RFI #: 192
 Date: 9/25/2012
 Job: EB-02 Keller Springs Lofts
 Phone: 877-777-5115

Subject: Steps at stair #8

RFI #: 196
 Date: 10/12/2012
 Job: EB-02 Keller Springs Lofts
 Phone: 877-777-5115

Subject: Hardi Panel at Meter Center Location

4L OF 6

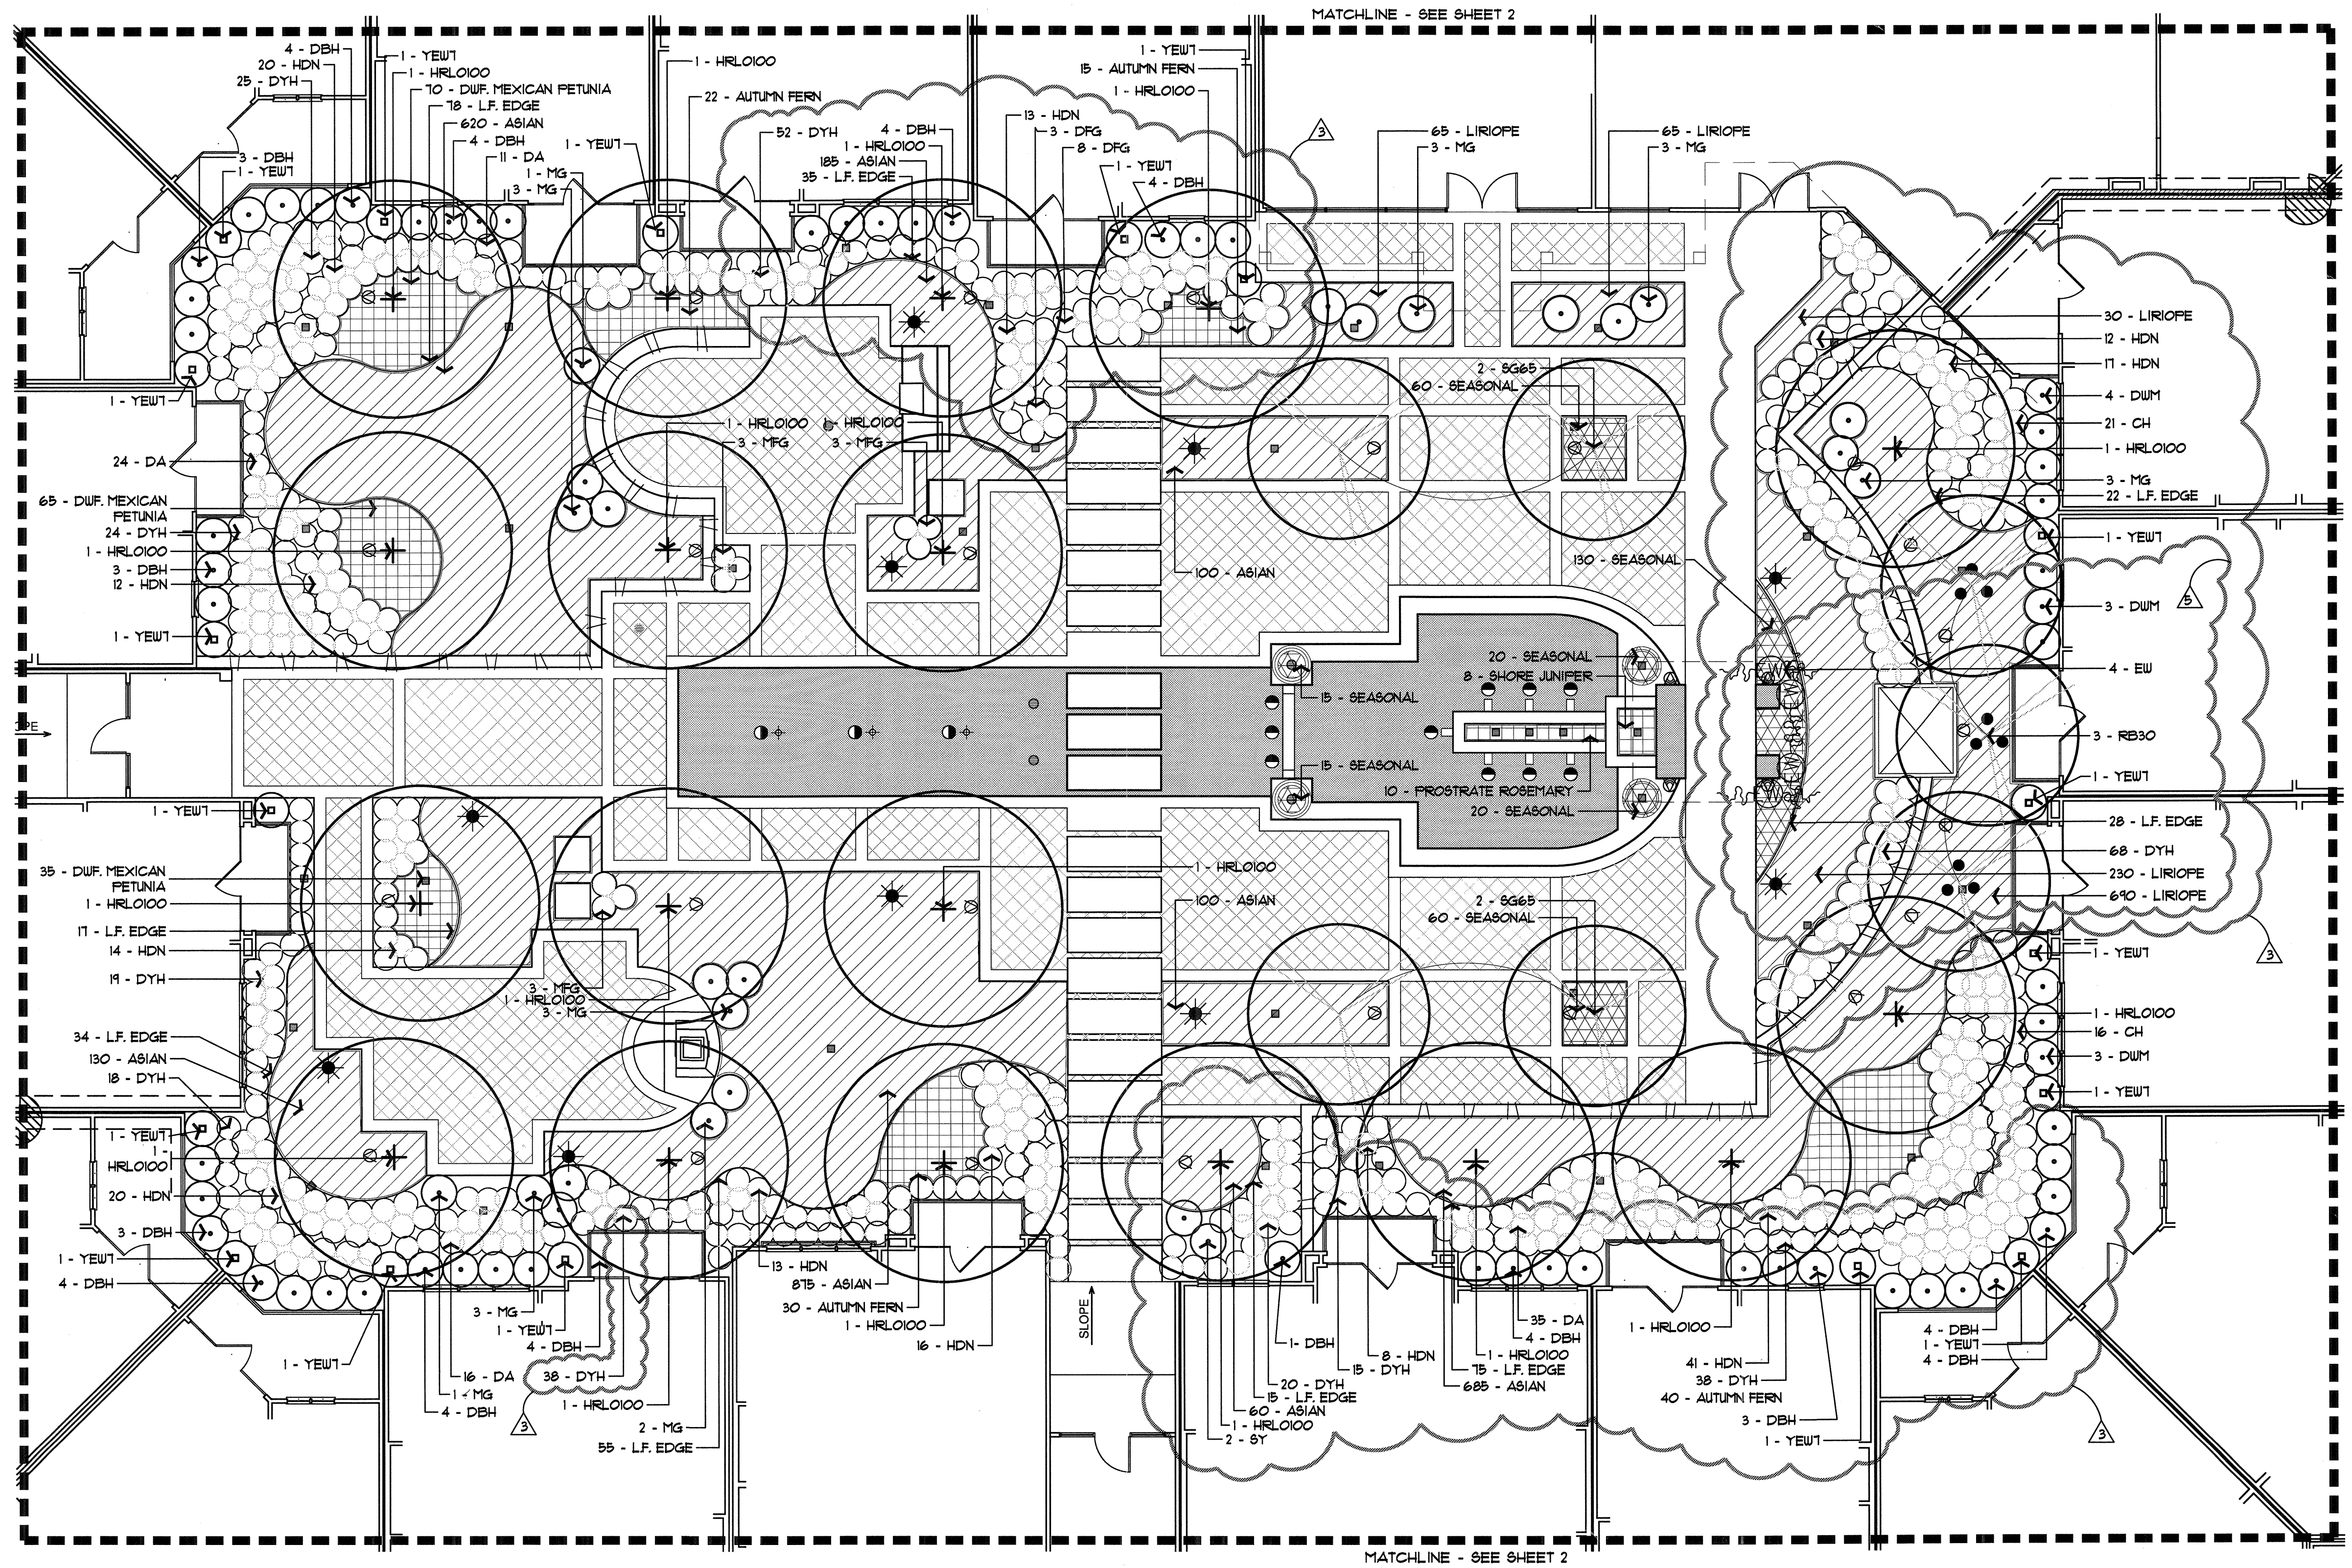
Request: Date Required: 10/2/2012
 There is a conflict on the Architectural plans at stair #8. On 3/4.1, 2/4.4, and 1/4.4 the building elevation shows steps leading into stair #8 at the exterior with an elevation of 64'1" - 7'3/4". On the Architectural and Structural foundation plans there are no steps and we agreed previously to make the elevation at the storefront 638.875 or 638' - 10 1/2". Please confirm that we are eliminating the steps and the foundation and landscape plans correct.

Response:
 BGO Response: The steps shown on the elevations in front of Stair #8 should not be there. If the landscape drawings added the storefront by stair #8, then it would be correct.
